Colorado Springs, CO

Final Report - Corrections Required **Application No. DEPN-26-0013**

Description : Development Plan to establish internal roadways and lots. No end-users are proposed with this development plan application.

Document Filename : DP_V1_02-03-26

SHEET
1 OF 6

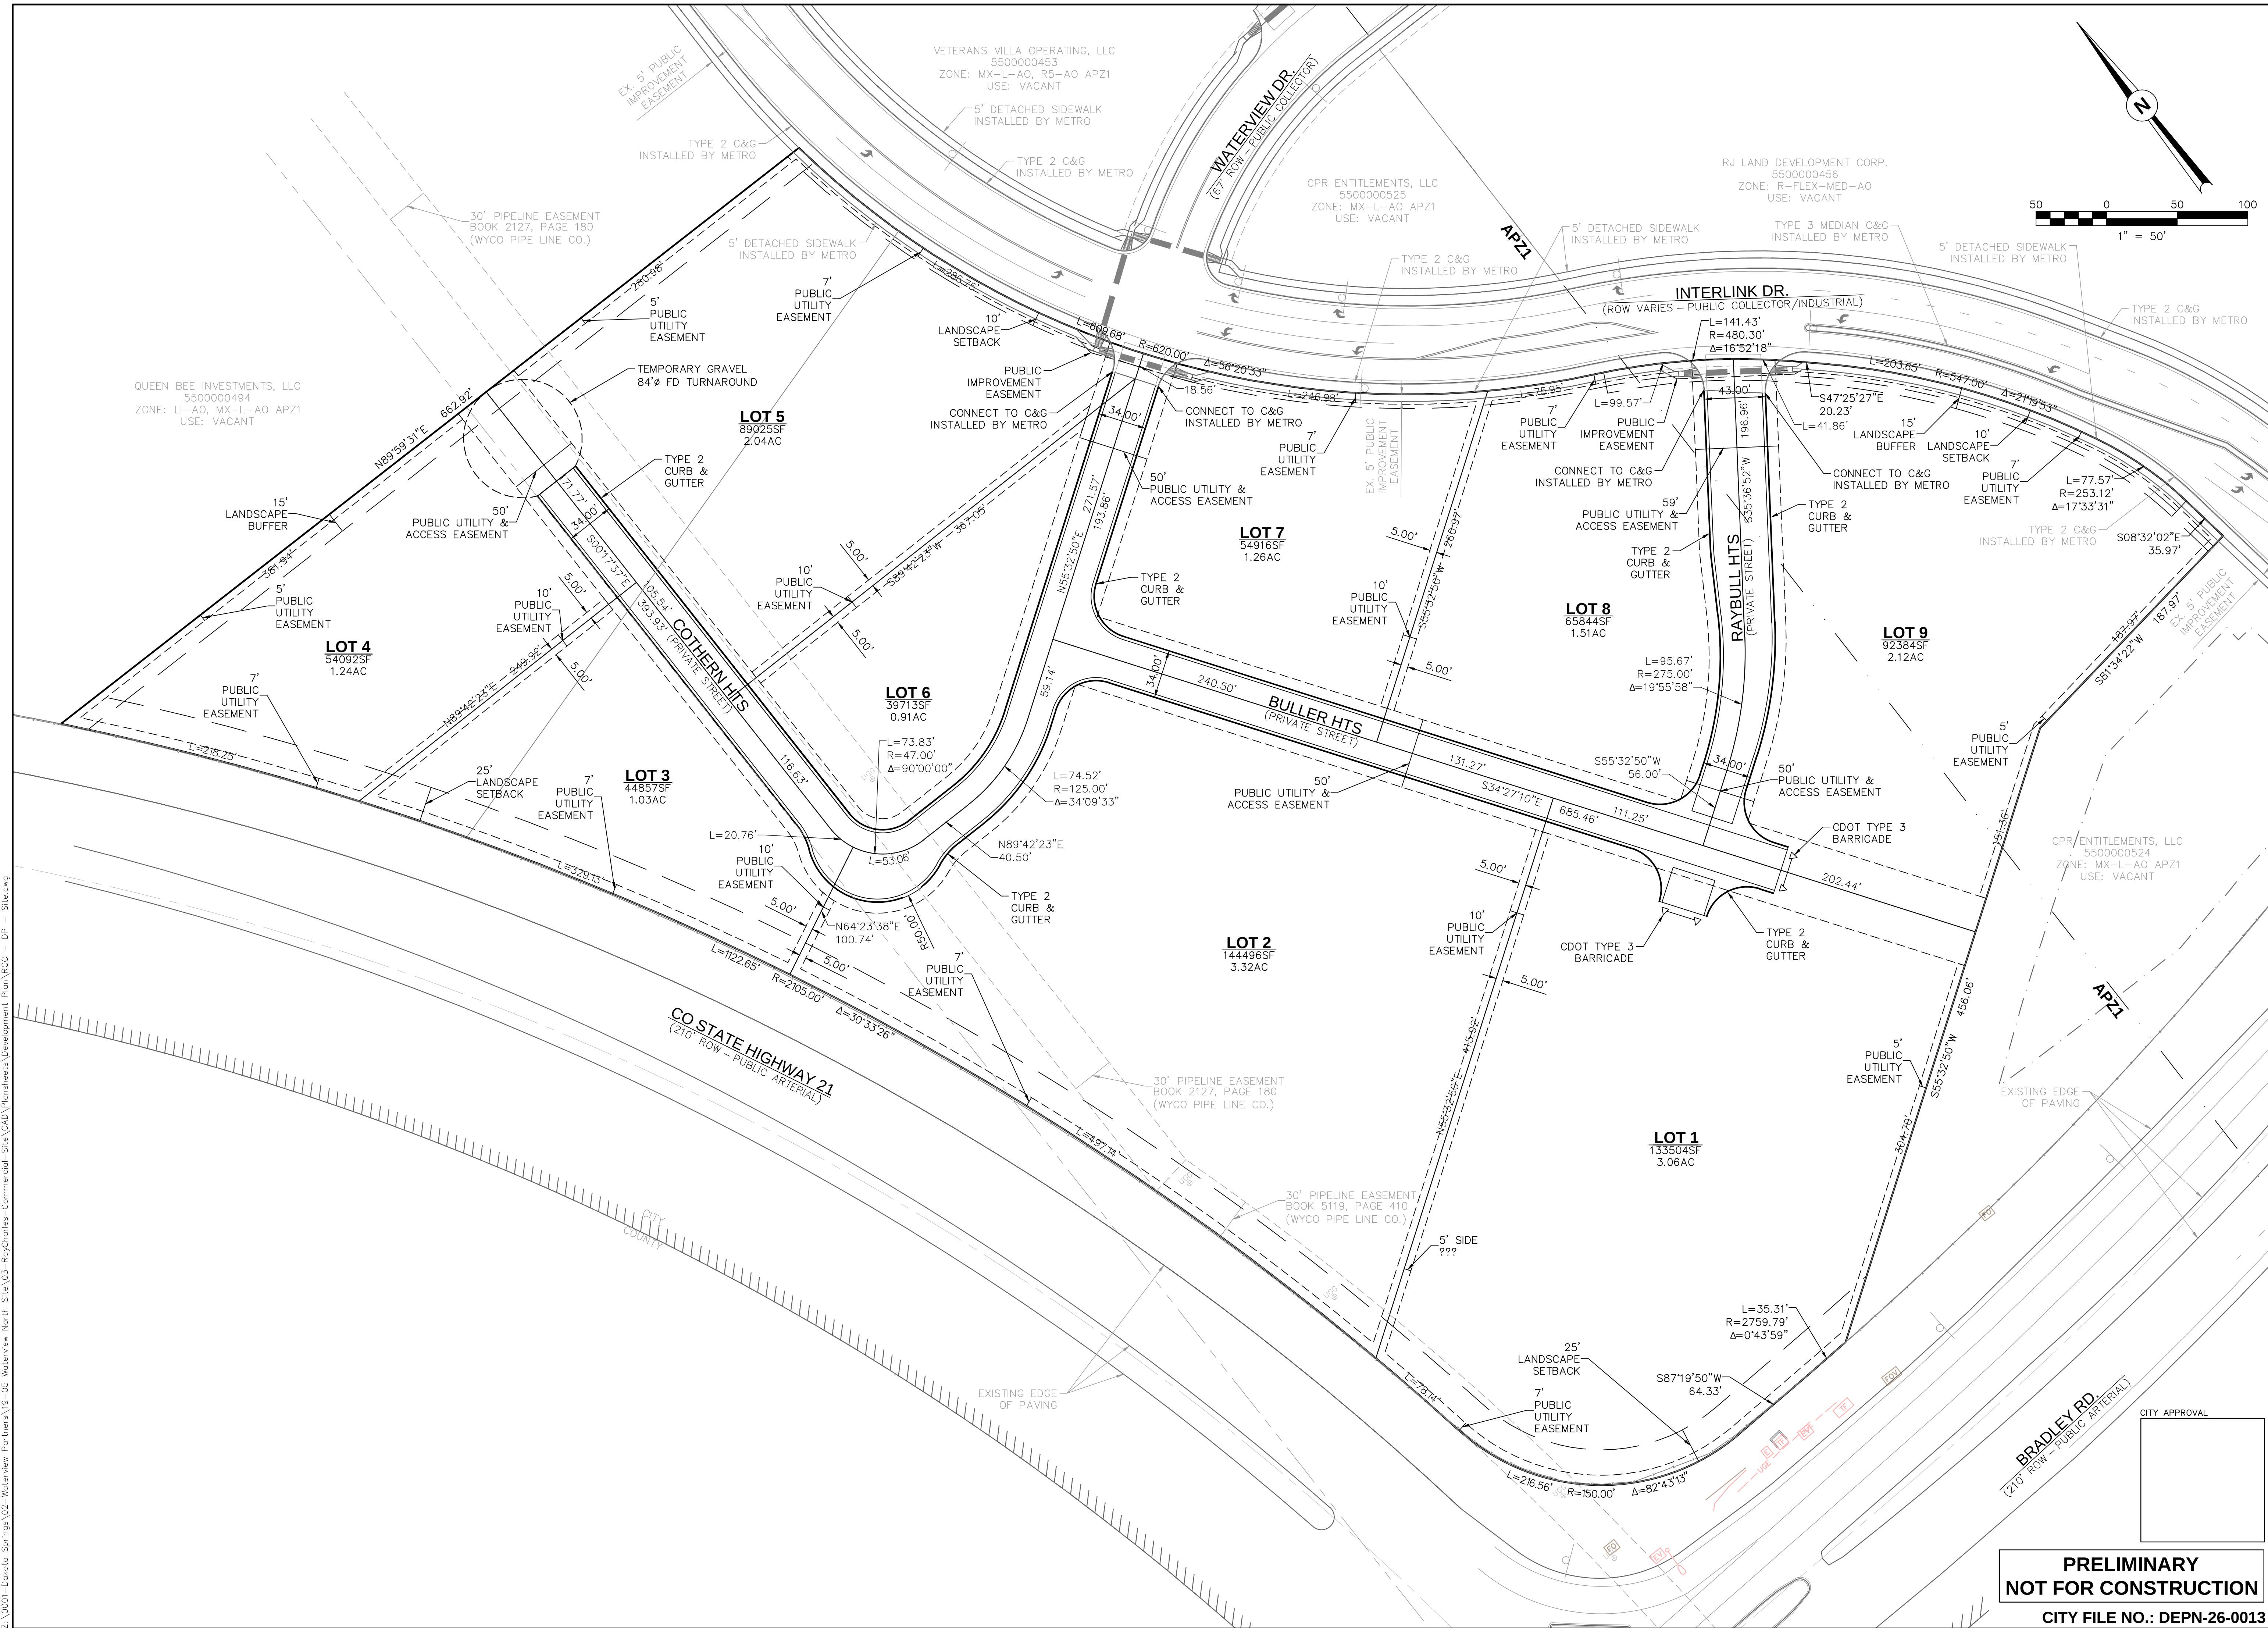
24	1	Joel Dagnillo : City Engineering Dev Review	Is final plat submittal forthcoming? Add final plat name to title block of this development plan.
25	1	Joel Dagnillo : City Engineering Dev Review	COPN-22-0002
26	1	Joel Dagnillo : City Engineering Dev Review	Please add the following notes to Cover Sheet: "All existing curb, gutter, sidewalk, pedestrian ramps, crosspans and driveway aprons posing a safety hazard, damaged, exhibiting excessive deterioration or not meeting current City Engineering Standards along all City public streets adjacent to the site will need to be removed and replaced prior to issuing the certificate of

Comment ID	Page Reference	Reviewer : Department	Review Comments
			occupancy (C.O.). An on-site meeting can be set up with the Engineering Development Review Inspector to determine what, if any, improvements are required. The Inspector can be reached at 719-385-5977." "Accessible routes, including ramps and sidewalks, within the public right-of-way shall be per the City's Standard drawings and Specifications. City's Engineering Development Review Inspector will have the final authority on accepting the public improvements." "Please contact Marisa Medrano (marisa.j.medrano@usps.gov) directly to review this development for mail service. To establish mail delivery and kiosk locations an appointment will be required with USPS to determine final locations. Information required for this establishment include proposed locations, type of mail receptacle, final plat with addresses, type of development (residential/commercial) and date of first occupancy."

Comment ID	Page Reference	Reviewer : Department	Review Comments
50	1	Steve Smith : Fire	Add note that the drives will meet the following: Facilities, buildings, or portions of buildings hereafter constructed shall be accessible to fire department apparatus by way of an approved fire apparatus access road with asphalt, concrete, or other approved driving surface capable of supporting the imposed load of fire apparatus weighing up to 75,000 pounds with a minimum single axle weight of 27,000 pounds.
51	2	Steve Smith : Fire	Temporary FD turnaround required until roadway is connected. Show the temporary turnaround on the plans. May be gravel.
2	1	Gregory Stachon : Planning	Will the landscape setback trees be installed by master developer then maintained by individual lot owners? If so, show trees on this plan. If not, clarify that "landscape setback trees to be provided by individual lots as they develop."

23	1	Caroline Miller : Planning	Please add a note: 'Citywide Development Impact Fees will be applicable for future developments, with fees due at time of building permit.'
52	1	Drew Foxx : Planning	Will an FLP/FIP be provided now or upon proceeding development plan modifications?
53	1	Drew Foxx : Planning	Revise: MX-L APZ 1 AP-O (Mixed-Use Large Scale and Airport Protection Zone 1 with Airport Overlay); Ord. 23-52 (City File No. ZONE-22-0014)
54	1	Drew Foxx : Planning	Lot coverage block is not necessary at this time. Please remove.
55	1	Drew Foxx : Planning	Please remove parking block and insert this note in the general notes.
56	1	Drew Foxx : Planning	Include the following in the site data block: - Master Plan: MAPN-22-0002 - Concept Plan: COPN-22-0002 - Drainage Basin: _____
57	1	Drew Foxx : Planning	Add city file number to the bottom right hand corner of each sheet.
58	1	Drew Foxx : Planning	Add box for future city stamp in lower right hand corner of each sheet.

59	1	Drew Foxx : Planning	Add "TO BE PLATTED AS...." description.
60	1	Drew Foxx : Planning	Remove second line of the height block.
65	1	Drew Foxx : Planning	Please include the following general notes: - No direct vehicular access shall be allowed onto Powers Blvd. from the parcel(s) within this development. - The parcels within this development are subject to the fees, restrictions, and covenants of the _____ district, which is created by ordinance no. _____ and recorded in the records of the El Paso County Clerk and Recorder's office under reception no. _____.
66	1	Drew Foxx : Planning	Temporary blockades should be placed at the end of the roadways where the future road will continue. Add note that these blocks shall be installed when the road is complete until such time the roadway continues.
3	2	Michelle Lavelle : Planning	Street names James View and Ray View are not available. Per 7.4.304H 2e Duplicate Street Names shall not be approved regardless of the street designation. Please submit street name reviews to StreetNamingLUR.SMB@coloradosprings.gov

DEVELOPMENT PLAN
SITE PLAN

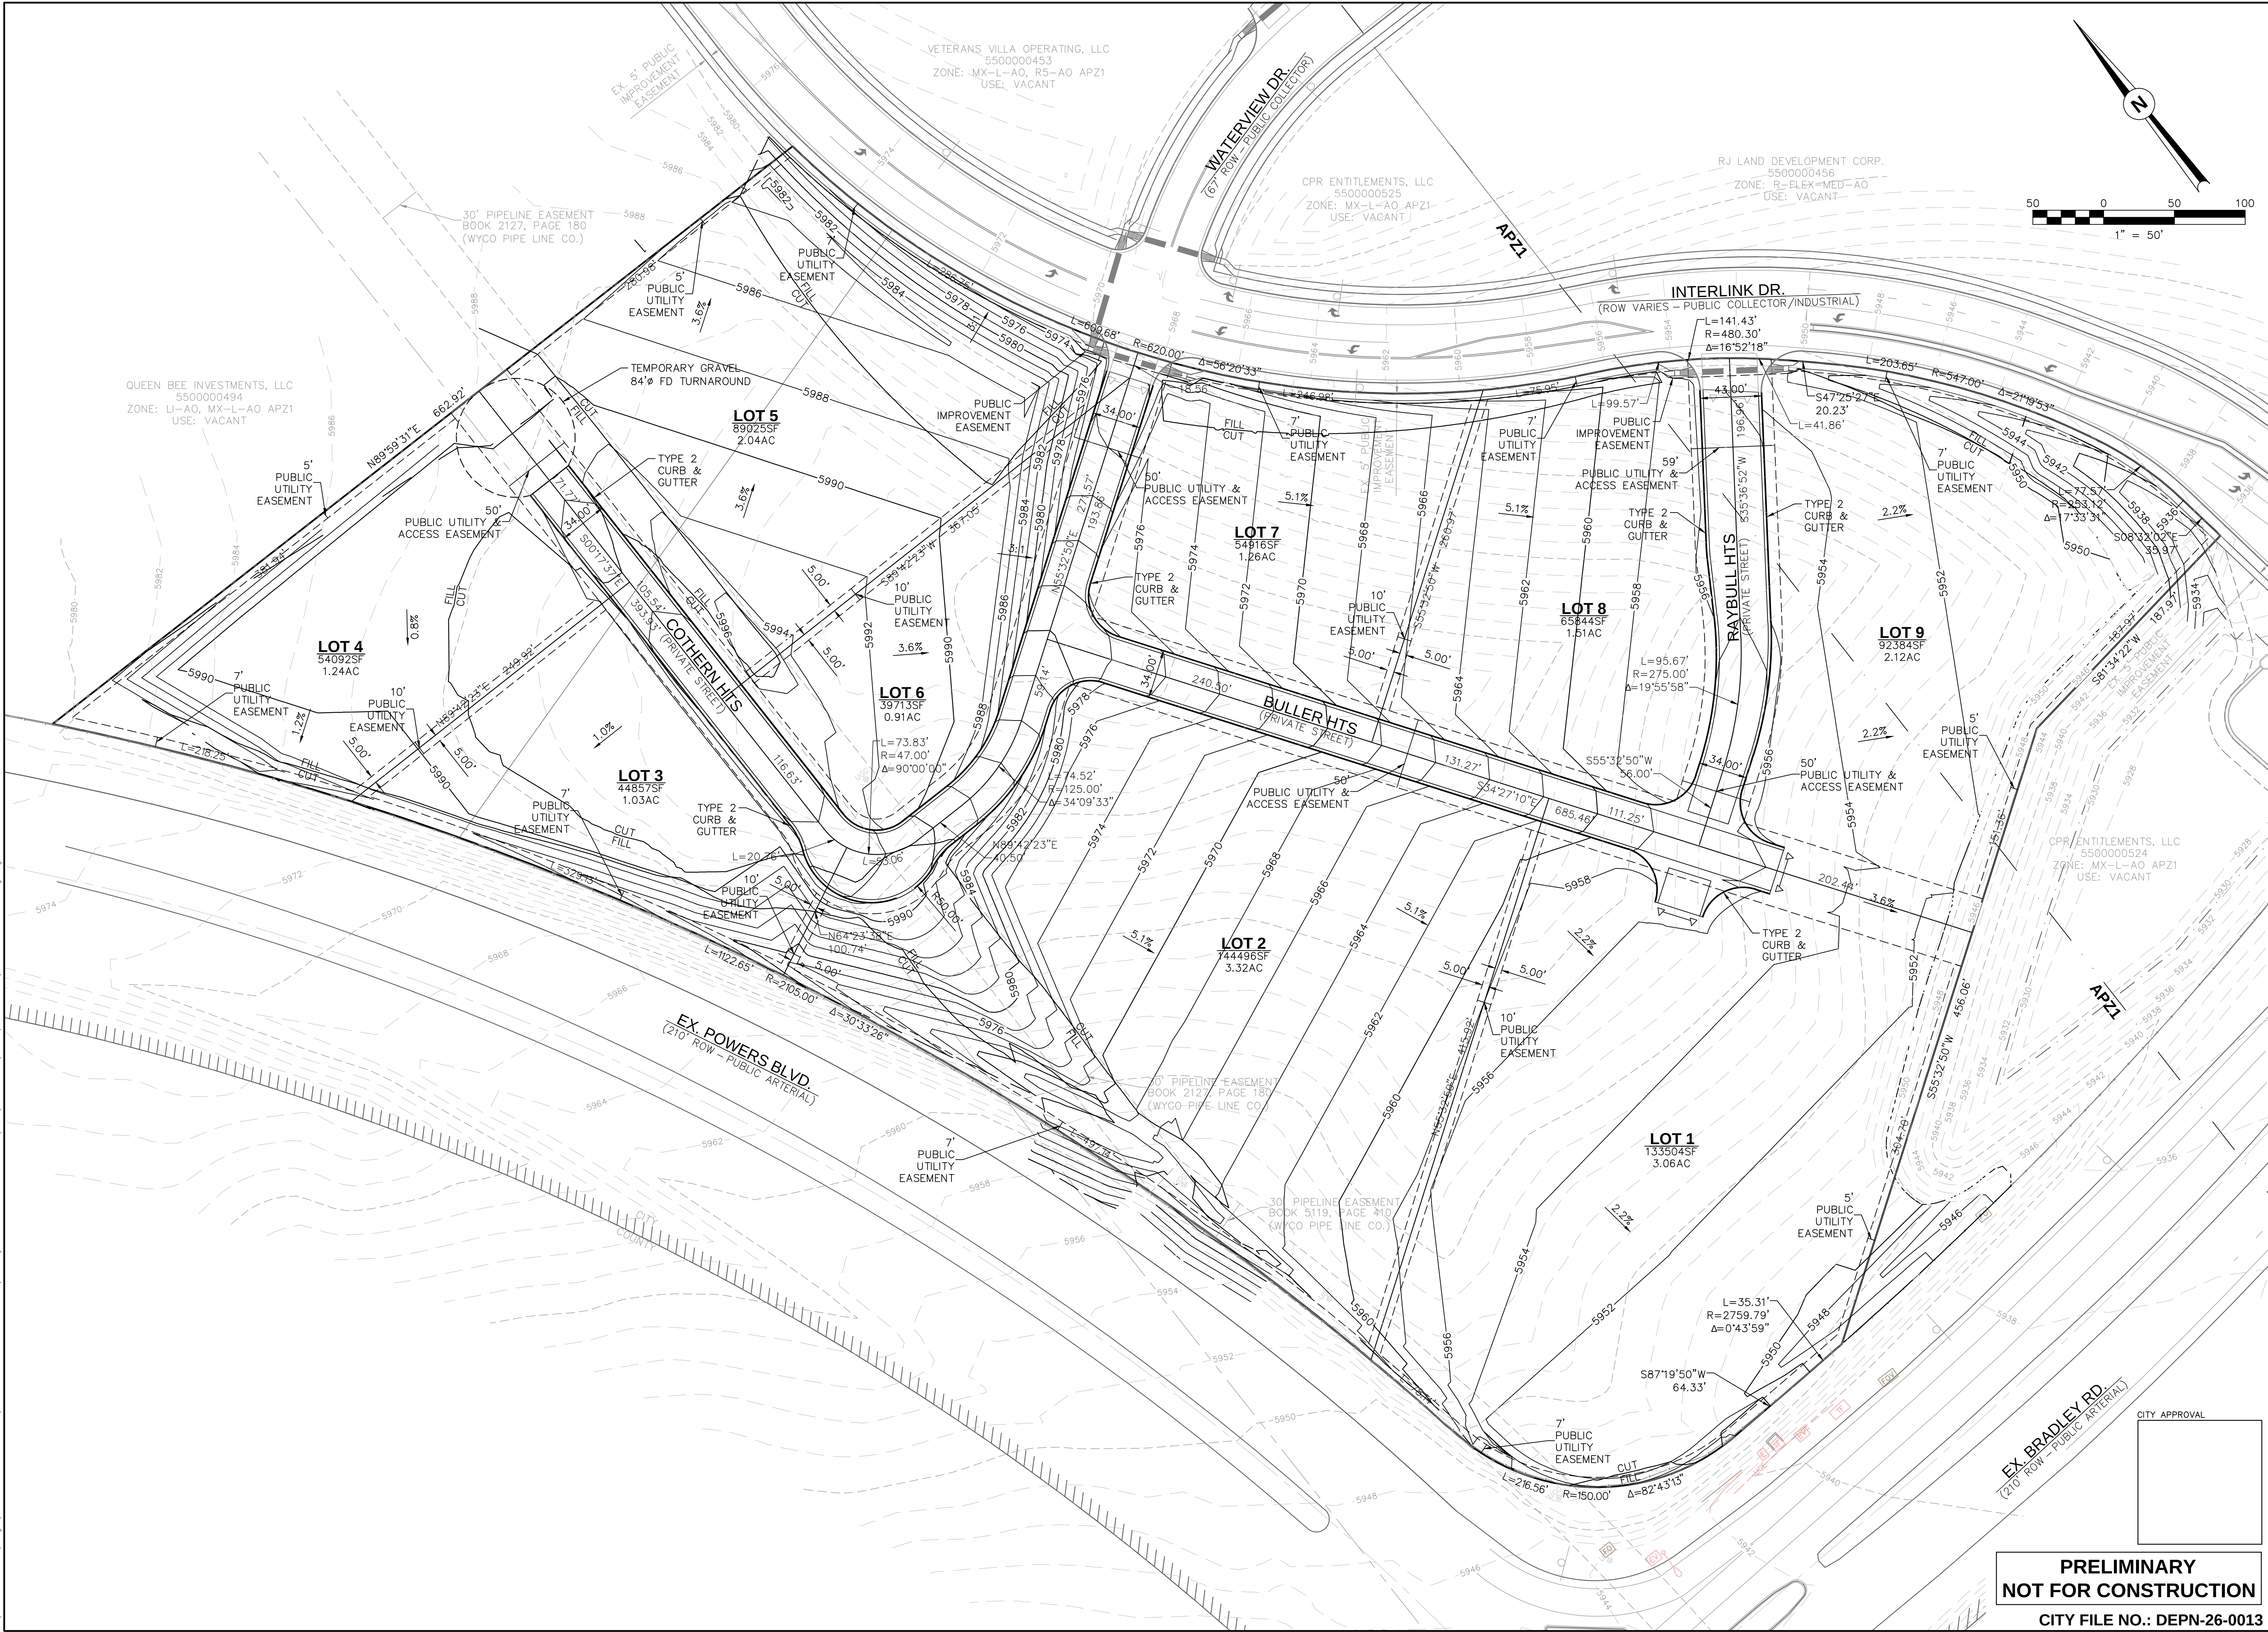
27	2	Joel Dagnillo : City Engineering Dev Review	Label Powers Blvd. as "Colorado State Highway 21"
28	2	Joel Dagnillo : City Engineering Dev Review	Please coordinate with CDOT regarding any required improvements or infrastructure along Powers Blvd.
29	2	Joel Dagnillo : City Engineering Dev Review	Please label and call out all public improvements along Interlink Dr. and Bradley Rd. (such as sidewalk, curb/gutter, pedestrian ramps) to be installed by the Metro District. These improvements are shown on separate City-approved street construction plans.
21	1	Patrick Dosch : Col Springs Utilities	Re-label as "Preliminary Utility and Public Facilities Plan"
20	4	Patrick Dosch : Col Springs Utilities	Confirm grading proposed in existing easement
7	6	Patrick Dosch : Col Springs Utilities	Please label ownership (as this is not shown on the CSU GIS)
8	6	Patrick Dosch : Col Springs Utilities	Add side lot easements (5') rear lot easements (7') per proposed or existing plat

4	2	Michelle Lavelle : Planning	Waterview Dr is a public ROW on the north side of Interlink Dr. The continuation is a Private this will need a different street name cannot be duplicated. Per 7.4.304H2e per 7.304H 6 - Private Street Name Designations: Any private street or right-of-way shall be designated as follows: Grove, Heights, Point, or View. Please submit street name reviews to StreetNamingLUR.SMB@coloradosprings.gov
62	2	Drew Foxx : Planning	Add width and reception number of all public utility and access easements.

Comment ID	Page Reference	Reviewer : Department	Review Comments
63	2	Drew Foxx : Planning	Label zone and use classification for this property.
64	2	Drew Foxx : Planning	Detail El Paso County boundaries.
